Components Division
Dunn NC #2383
200 Emmett Rd, Dunn NC 28334
910-892-8400

After reviewing the information, this letter is to address the roof trusses for the KB Homes job, Lot 72 Birchwood Grove.

Drawing file: SFD2203-0057 / 72 Birchwood Standard Repair Detail.pdf

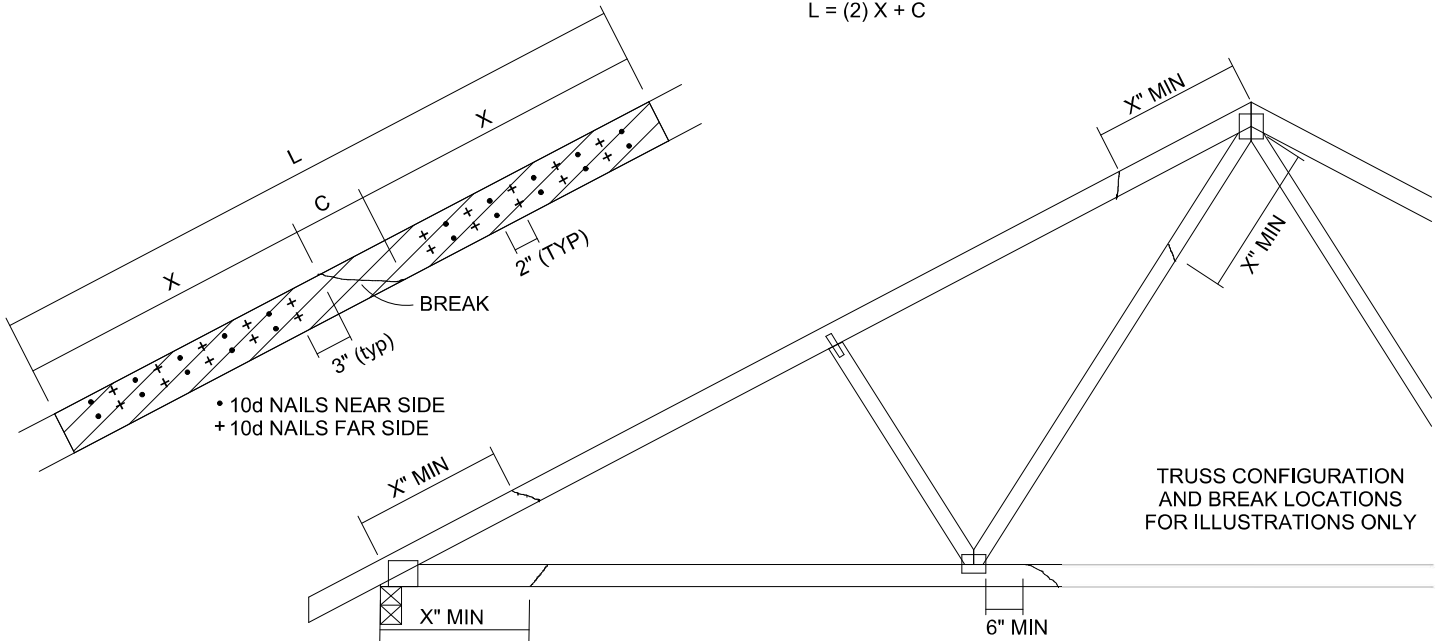
In reference to the HG truss where the top chord is cracked. Please refer to the sealed standard repair detail for field correction. This truss will perform as designed. Please feel free to reach out if you have any questions or concerns.
